Recommendation: Refuse

Applicant: J H Norman & Sons

Proposal: Erection of a two storey rear extension with single storey lean-to side element, together with a minor enlargement of the open framed canopy over the front door

TITLE
PROPOSED ELEVATIONS

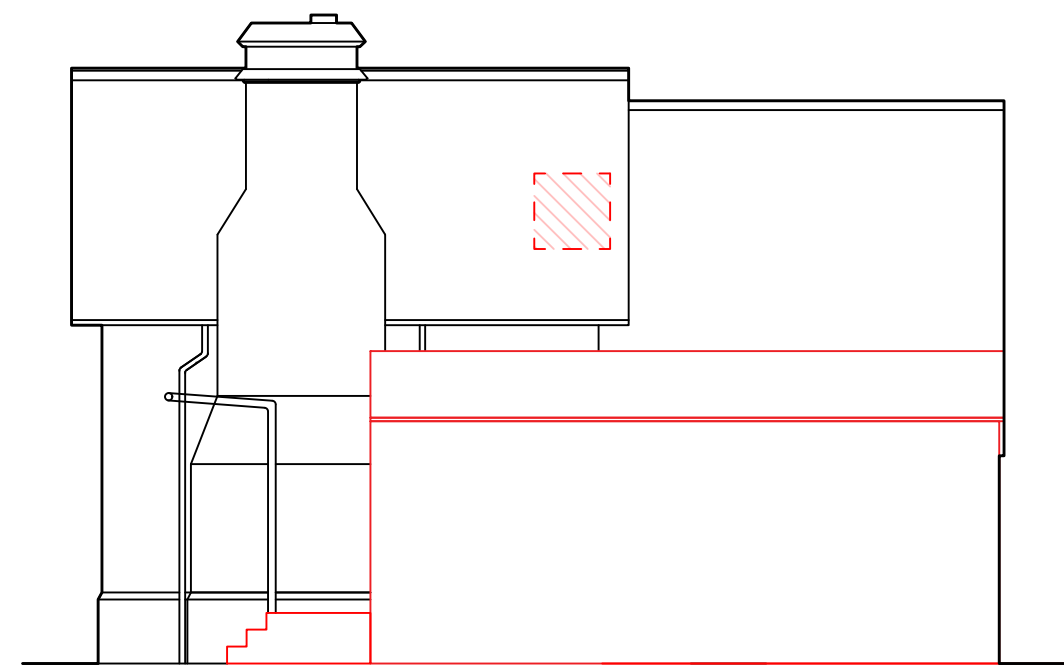
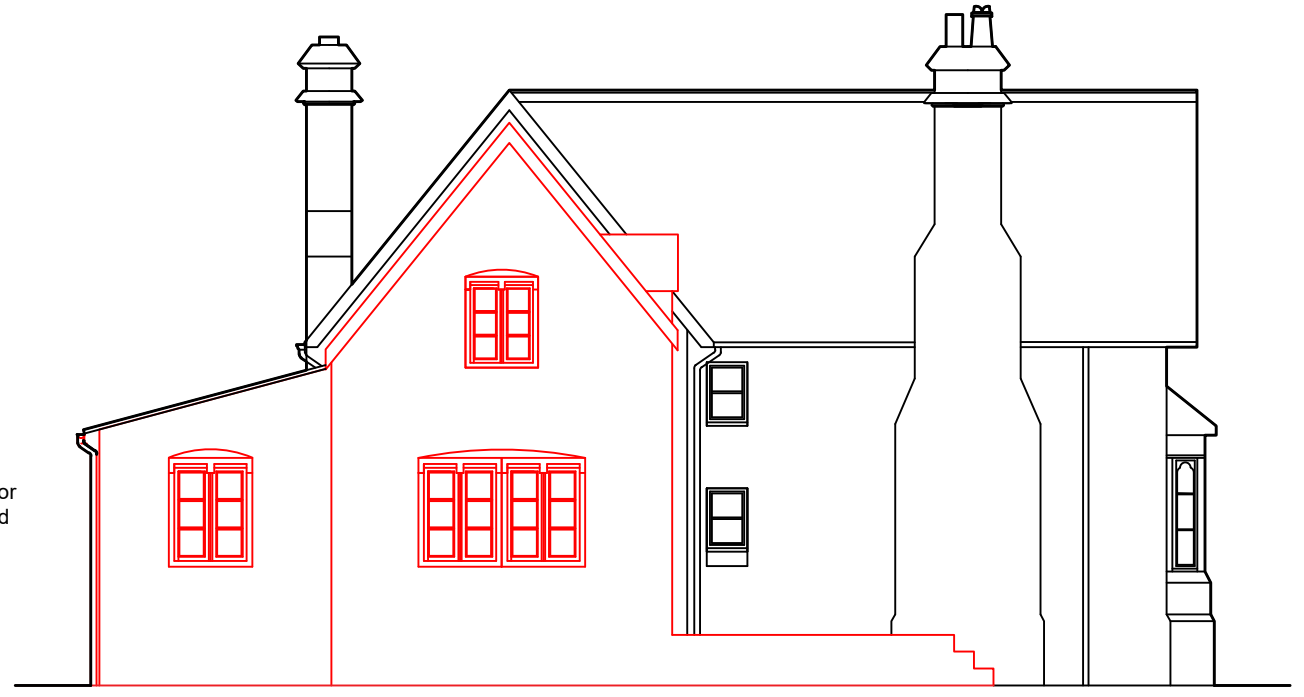
I am afraid that we cannot support the proposals in their current form. Although the current proposals constitute a slight improvement on the previous proposals, we are concerned that the proposed extension is overly large in scale and is not subordinate to the existing historic building. In addition, the proposed side extension acts to mask existing architectural detailing. We would strongly recommend that the rear extension is reduced in scale, ideally to single storey and some kind of visual separation is introduced between the old and new elements of the building. In addition, we have concerns that the proposed fenestration is not in keeping with the style of the building, particularly to the south elevation. The relocation of the front door and the proposed infilling of the front porch is not supported as these features make an important contribution to the original design and should be retained in situ, whilst the proposed four panel door with lintel to the single storey extension is not in keeping with the prevailing Victorian gothic style of the building featuring distinctive pointed arched doorways.

Whilst I acknowledge that the proposed extensions have now been reduced in size, they remain of substantial footprints and would be positioned upon the most visually prominent elevations when viewed from the adjacent B4030 road. The existing neat and attractive gable feature on the western elevation, with characteristic eaves detailing, would be largely obscured, and whilst I acknowledge that the eaves features and first floor window would be replicated within the extension, I am concerned regarding the large size of the ground floor opening within the gable and the interruption of the view of the existing gable by the proposed dormer windows. When combined with the depth of the two-storey extension taken from the original

wall, almost doubling the depth of the existing dwelling, and the lack of any visual breaks or openings in the northern elevation, I consider that the extension would continue to appear as a bulky and dominating addition to the existing dwelling.

The appearance of the two-storey extension is worsened by the addition of a shallow pitched single storey side extension that would run across the northern elevation of both the extension and the existing dwelling. The shallow pitch and bland design of single storey extension would not be in-keeping with the appearance of the Victorian gothic style of the existing dwelling. The extension would also cut across part of the existing chimney feature upon the northern facing elevation of the extension, appearing awkward and disrespectful of this non-designated heritage asset. The introduction of a second front door upon the eastern facing elevation of the dwelling also results in a confusing frontage, with visitors to the dwelling likely to be unable to discern which is the main entrance to the dwelling.

It is considered that the extensions, by virtue of their size, design and siting would appear as bulky, overly prominent, unsympathetic and discordant additions to the dwelling that would erode the distinctive gothic design of the existing dwelling and draw undue attention to themselves, detracting from the visual amenities of the area and resulting in less than substantial harm to the historic significance of this non-designated heritage asset.
